Final Report - Corrections Required
Application No. ANEX-23-0015

Description : A request by Norris Ranch Joint Venture, LLC, for annexation of 1,834.298 acres into the City of Colorado Springs. The annexation is a part of the overall Karman Line Land Use Plan, which is being submitted concurrently. The Land Use Plan proposes a maximum of 6,500 dwelling units, approximately 45 acres of light industrial, 105 acres of commercial/retail, 100 acres of mixed-use development, and 570 acres of park/open space.

April 24, 2023

Re: Karmen Line Addition

Figure 4
Existing Traffic Conditions

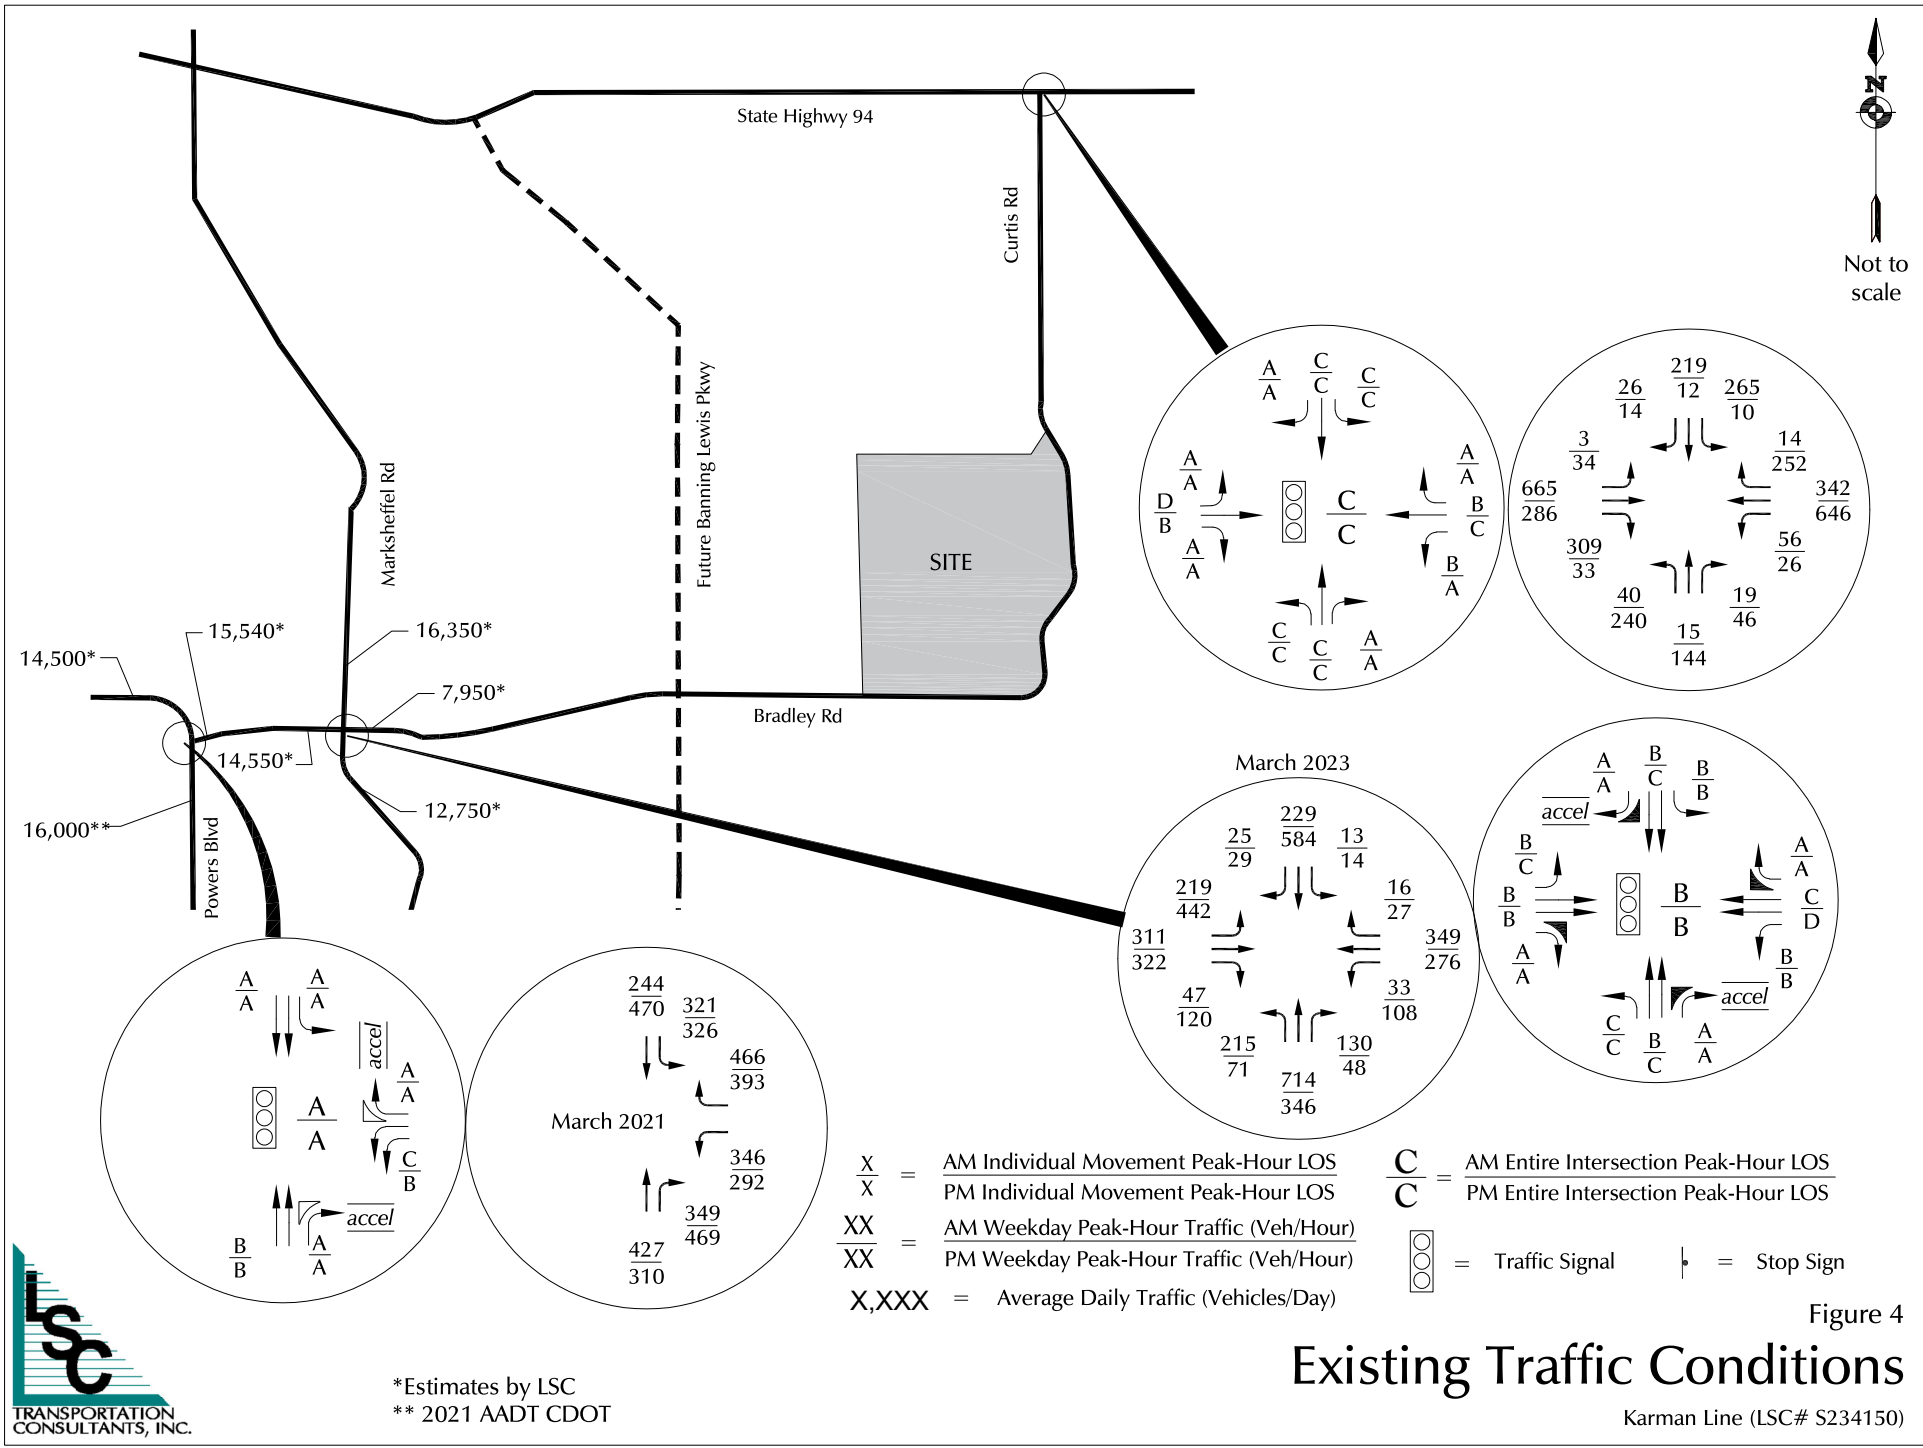
Transportation Memorandum: pages 2, 5, Figure 4, Figure 5

Figure 5
Directional Distribution

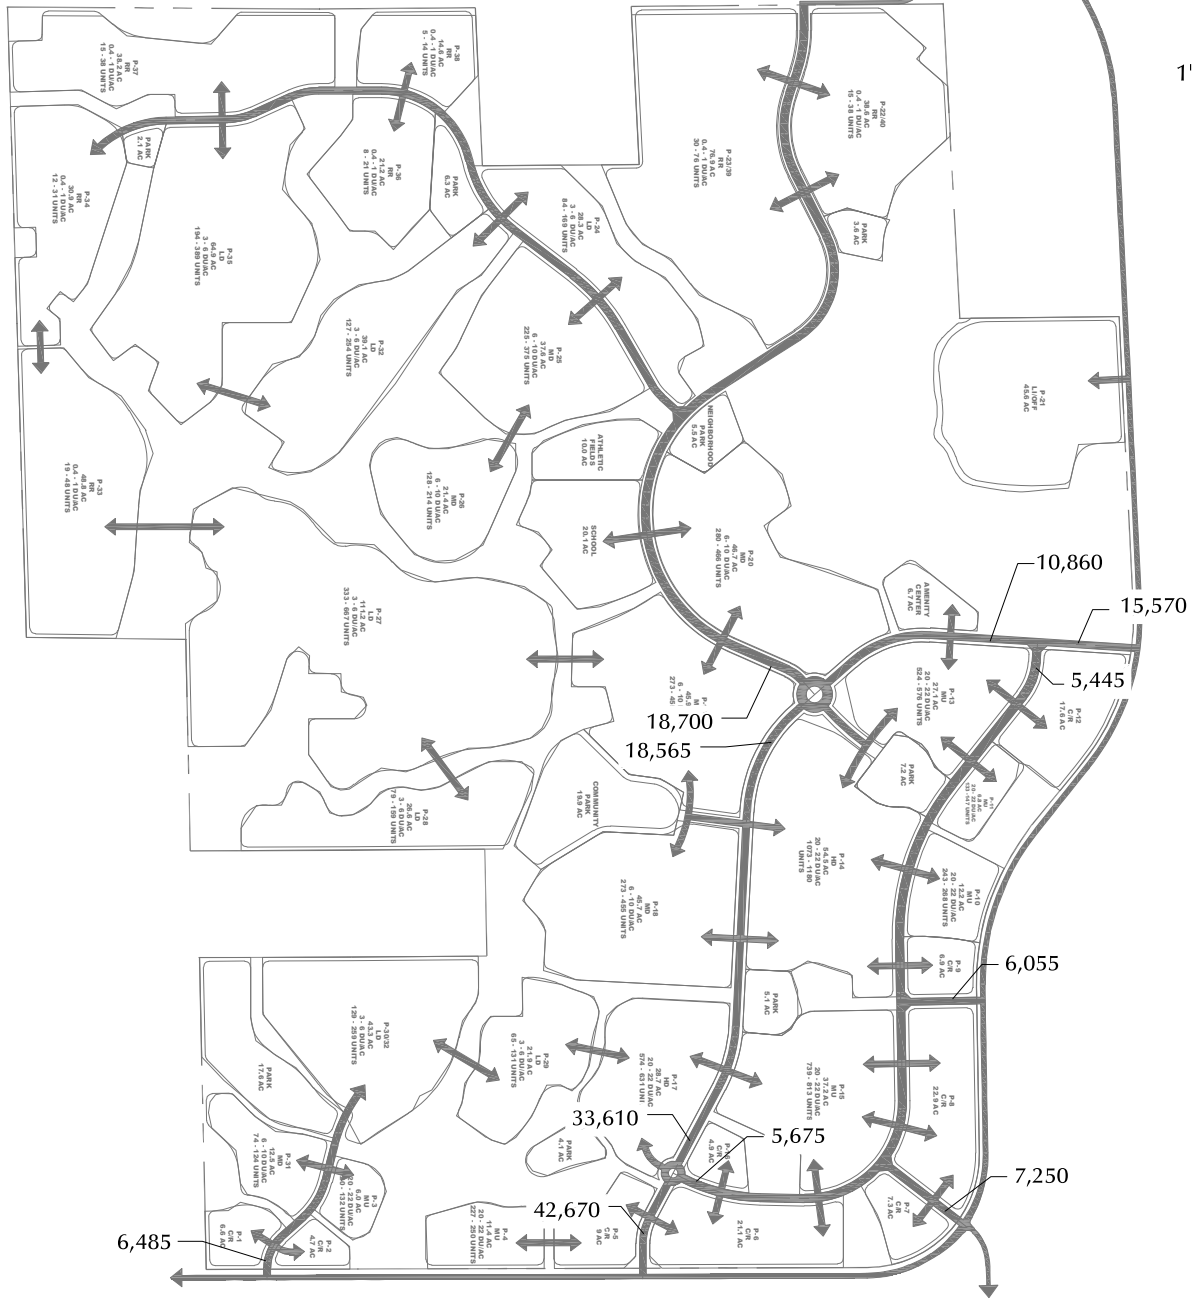
Verify that totals
← add up to 100%
(10-17% missing?)

Figure 8
Recommended Classifications

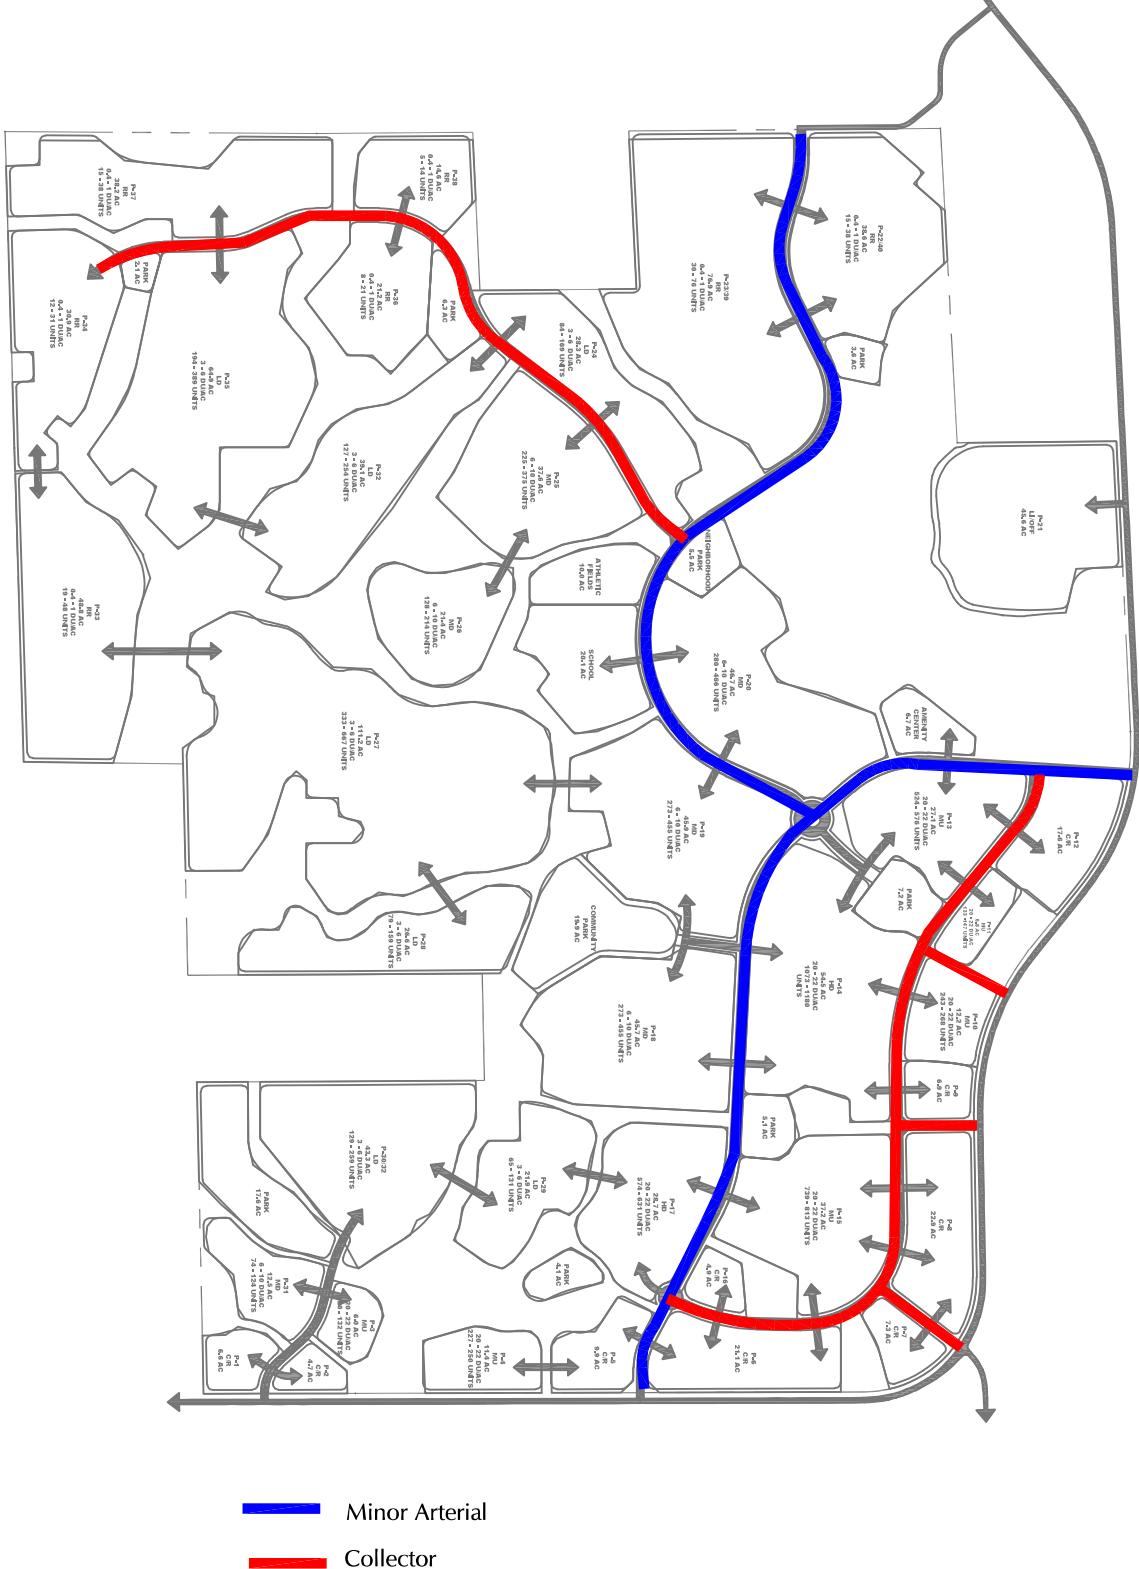
Please discuss any changes in the roadway classification of Bradley Rd and Curtis Road due to the developments traffic.
